HAY CREEK VALLEY

FINAL GRADING & EROSION CONTROL PLANS

SEPTEMBER 2023

EPC STORMWATER REVIEW COMMENTS
IN ORANGE BOXES WITH BLACK TEXT

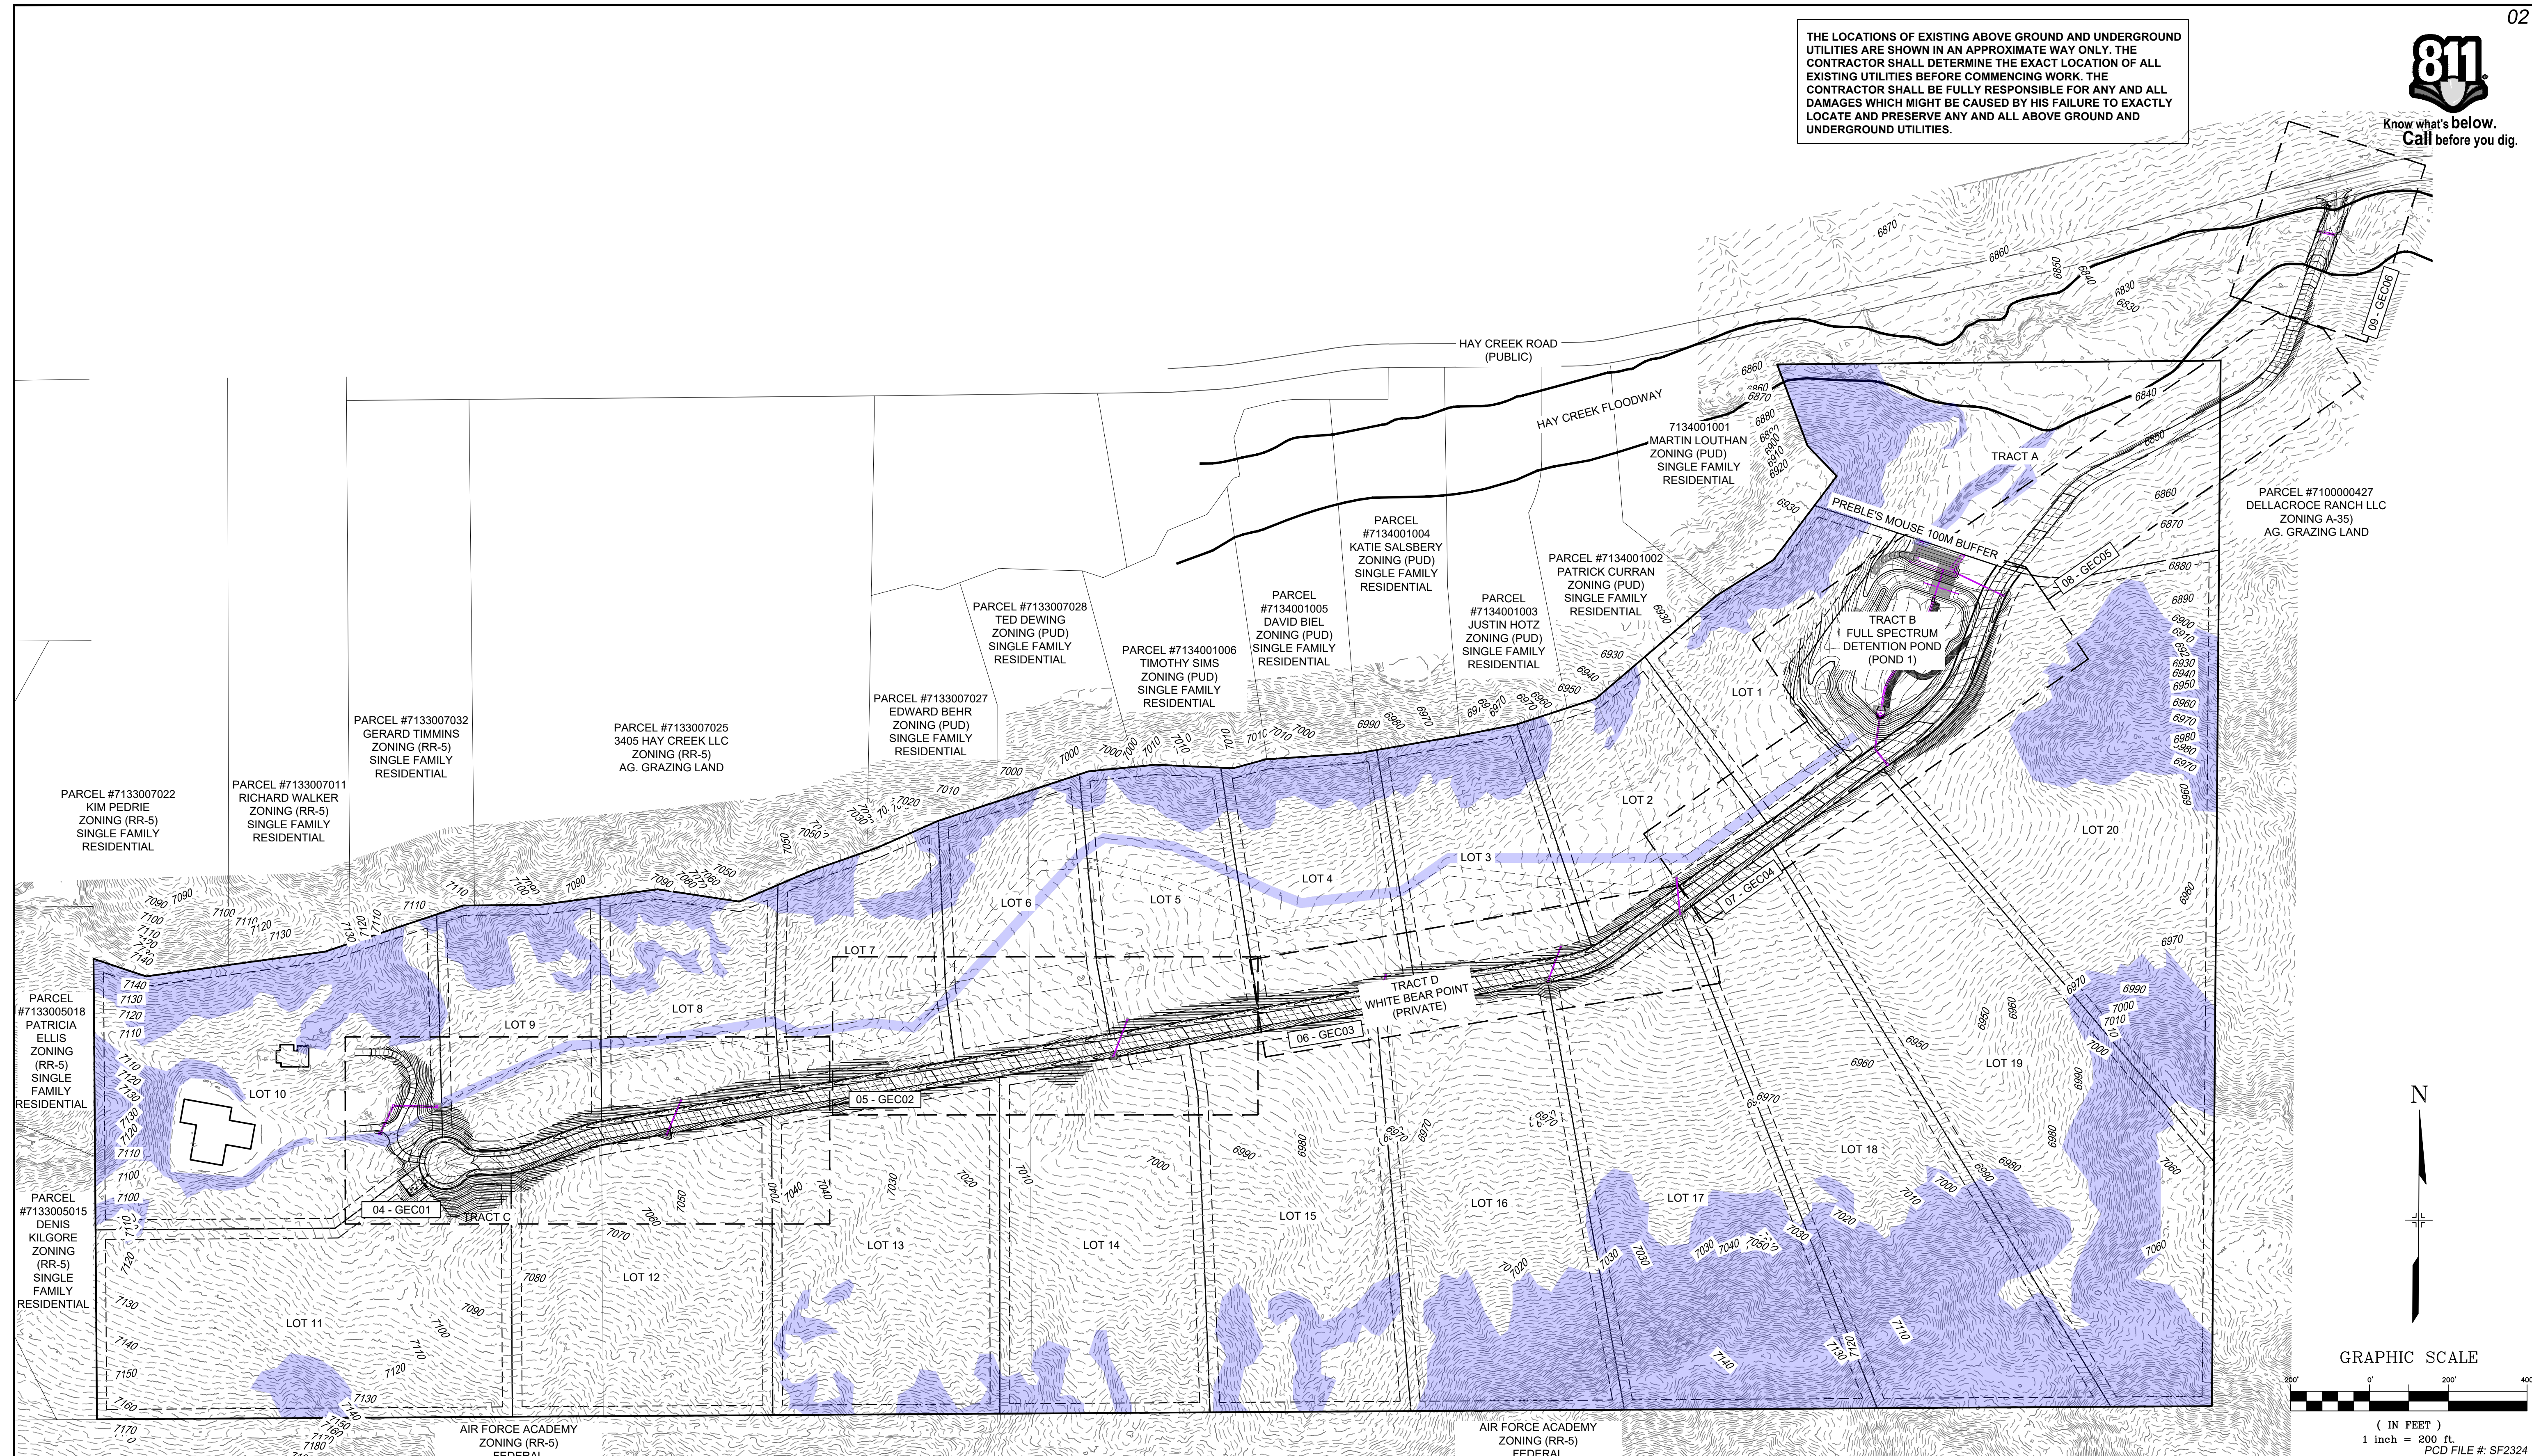
Add text:
EPC's EDARP File Number: SF2324

ADDRESSED

HAY CREEK VALLEY EL PASO COUNTY, COLORADO FINAL GRADING & EROSION CONTROL PLANS GENERAL NOTES. Includes project details, scale, date issued (January 2024), and drawing number GN02.

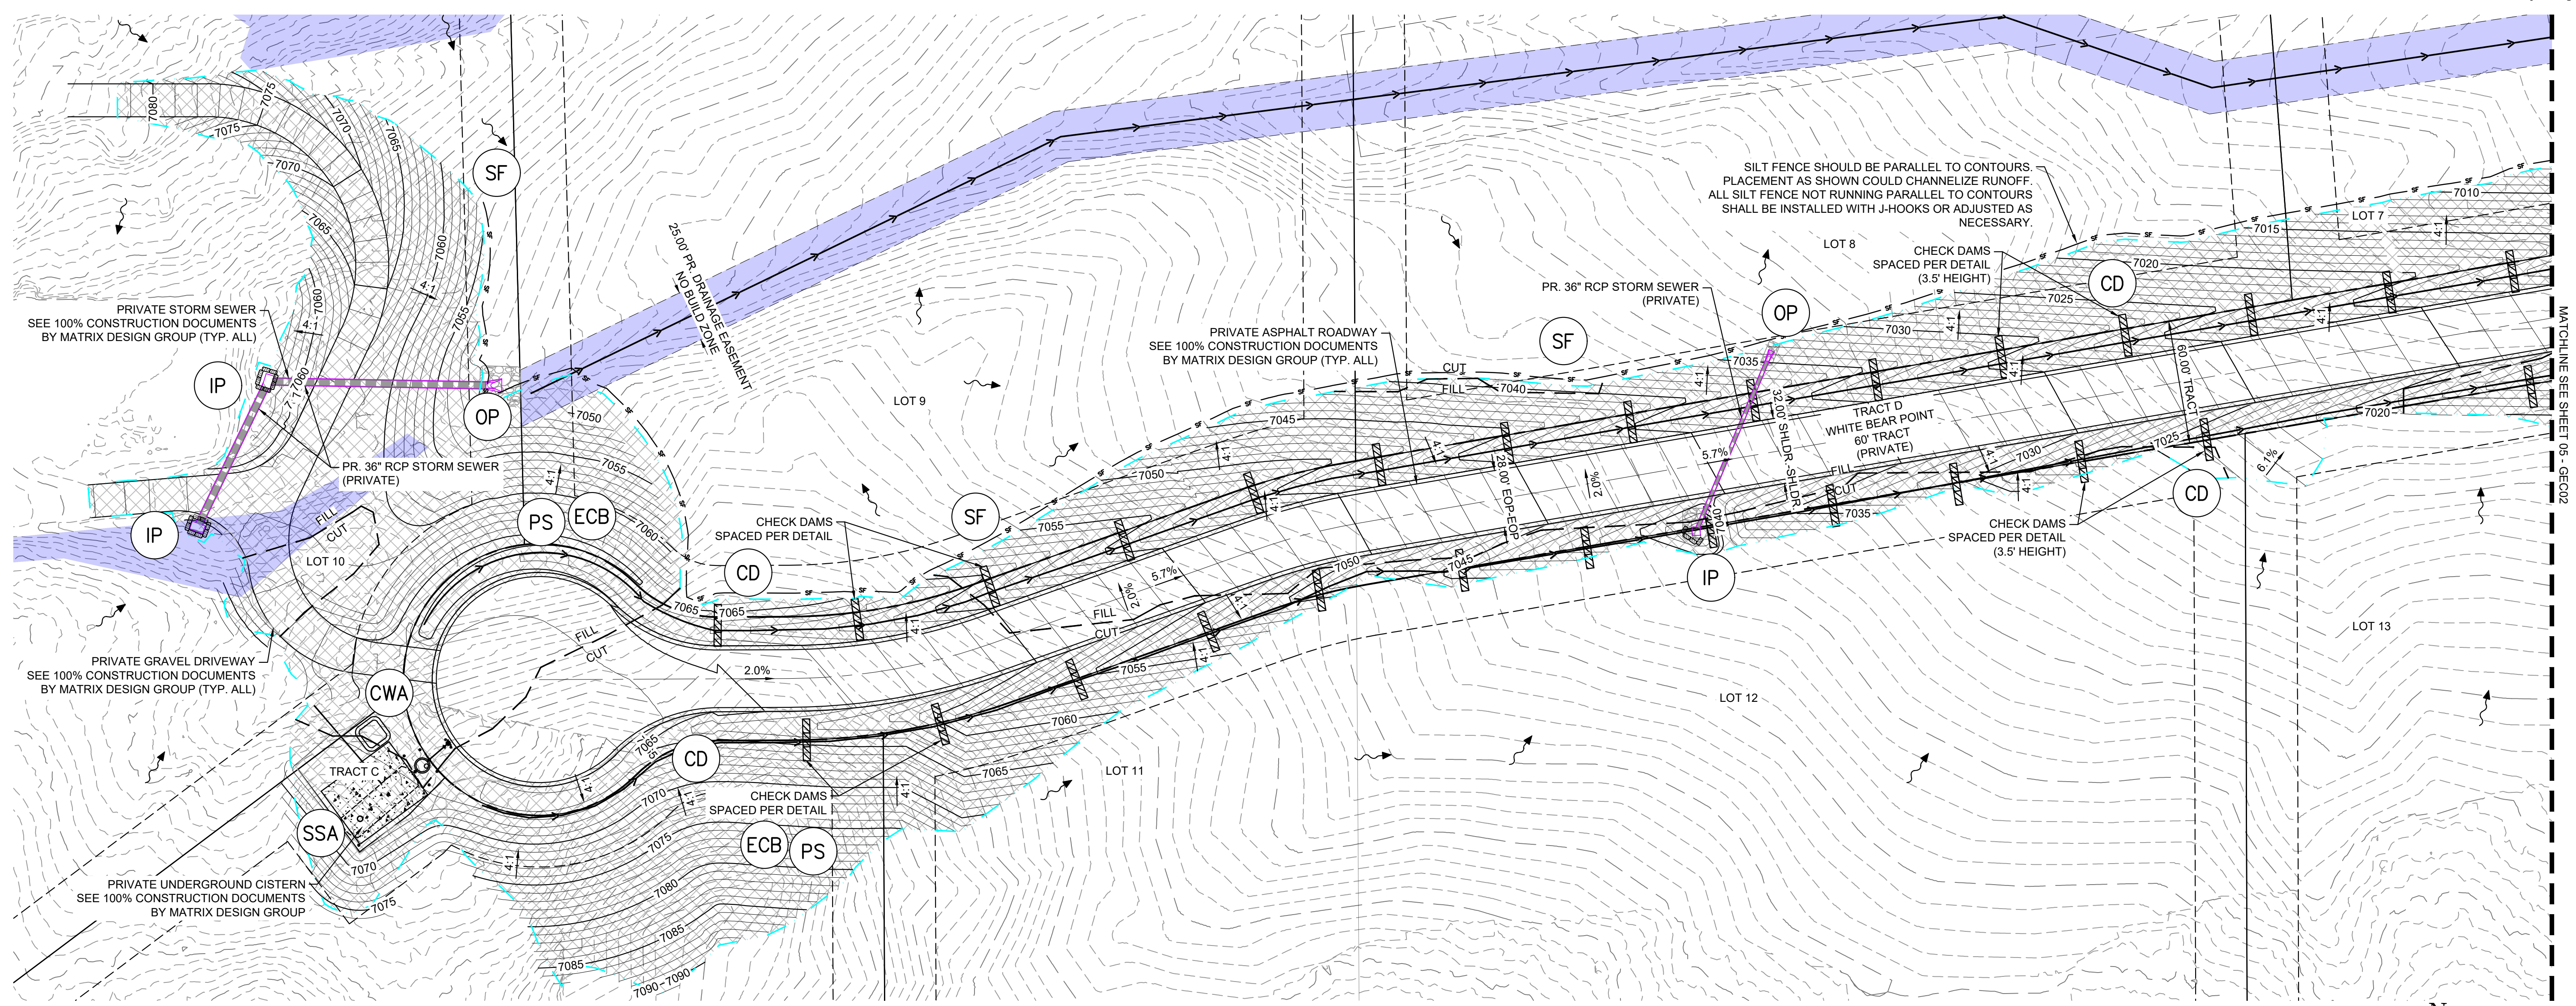
Update to future dates.

ADDRESSED

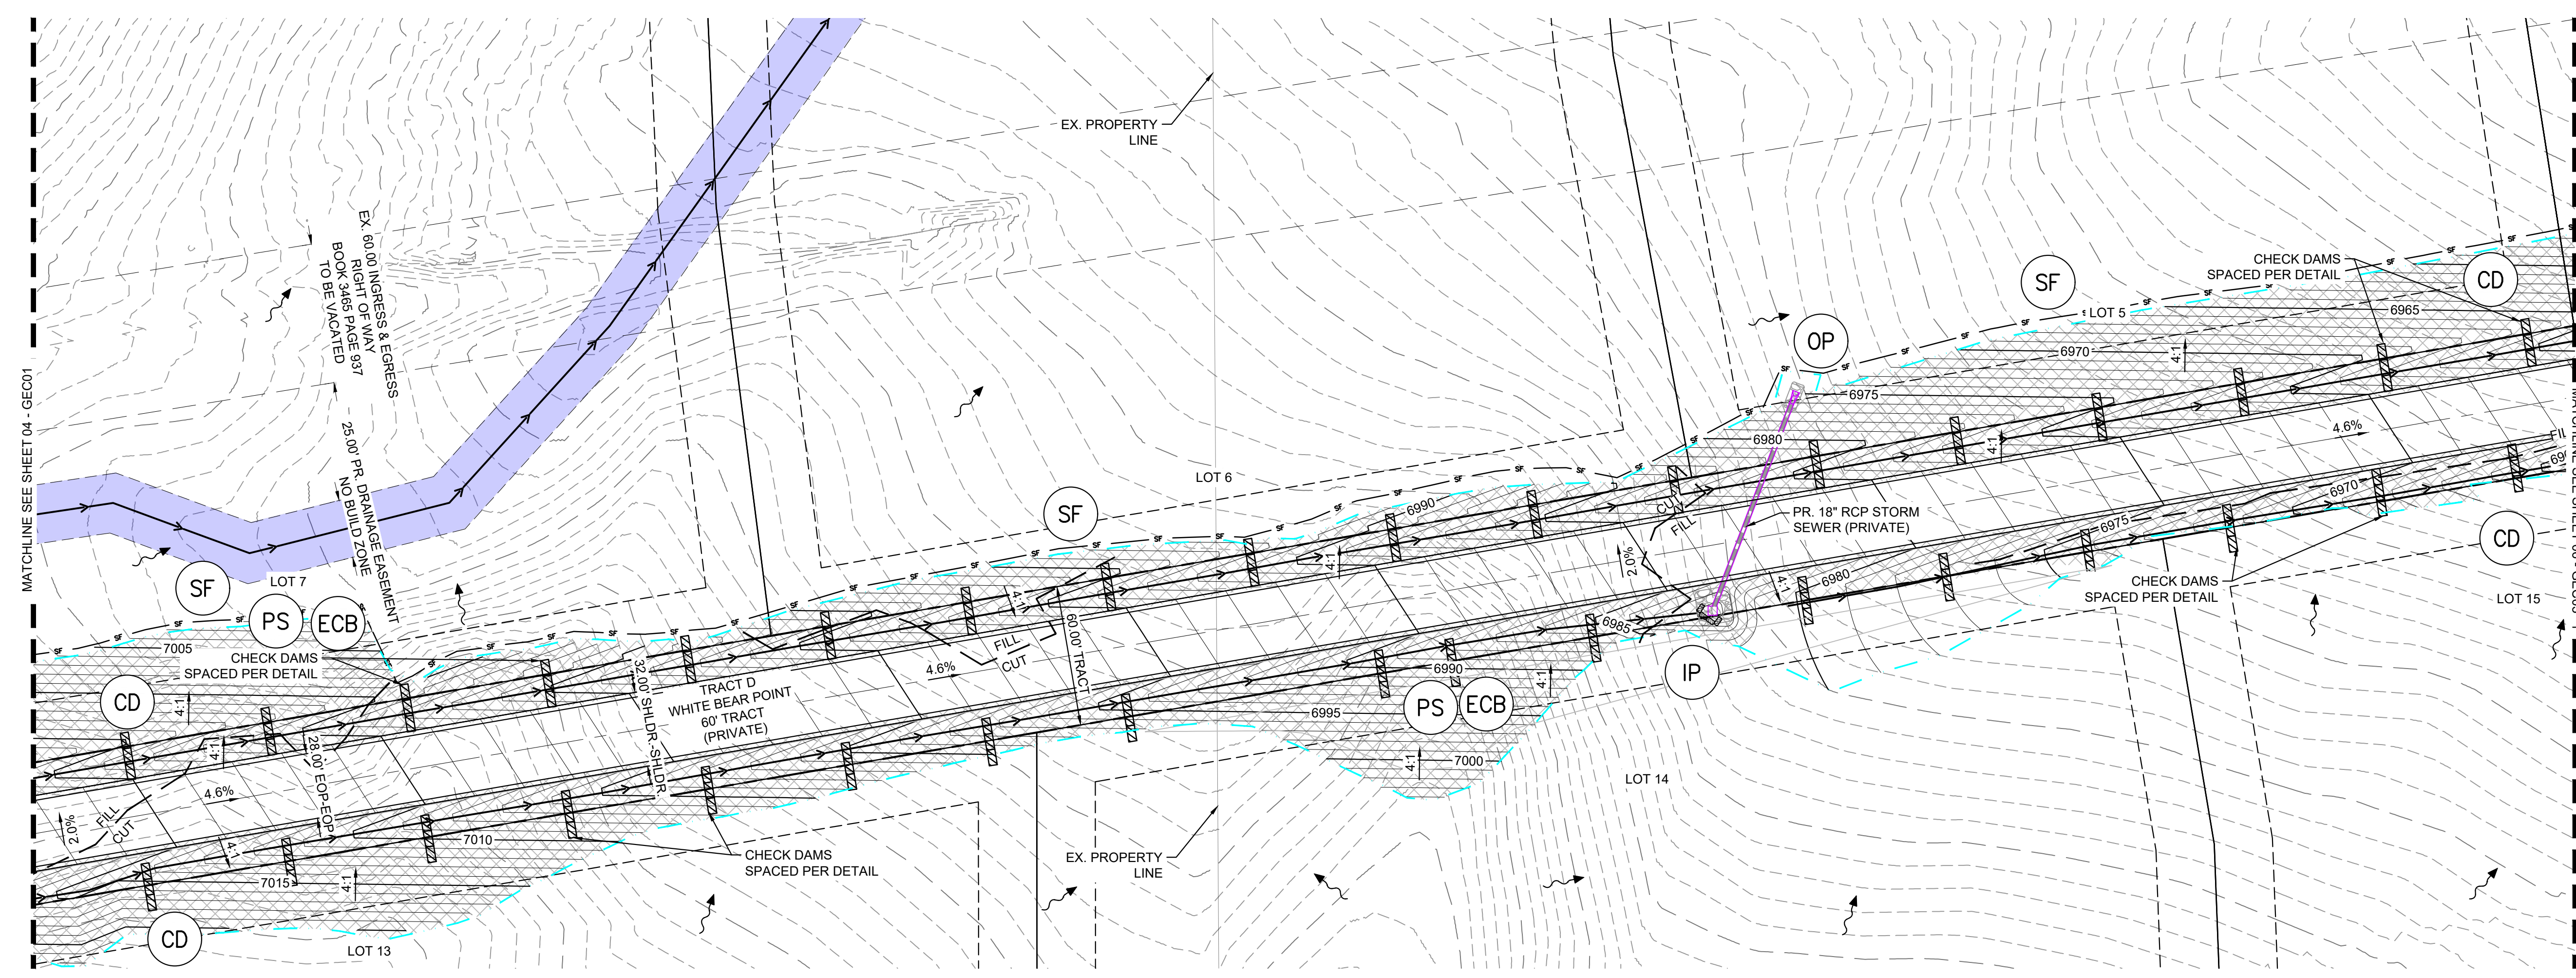
GEC Checklist Item j - show FEMA floodplain areas in legend and on plans, clearly define.

This rock hatching is labeled as VTC in the legend, will these proposed ditches be riprap lined? If so add to the legend

seeding/mulching also should be included in the final stage and in the legend. All disturbed areas should be seeded.

Show check dams in legend.

ADDRESSED

VTC HATCHING REVISED TO DIFFERENTIATE BETWEEN RIP RAP

ADDRESSED

ADDRESSED
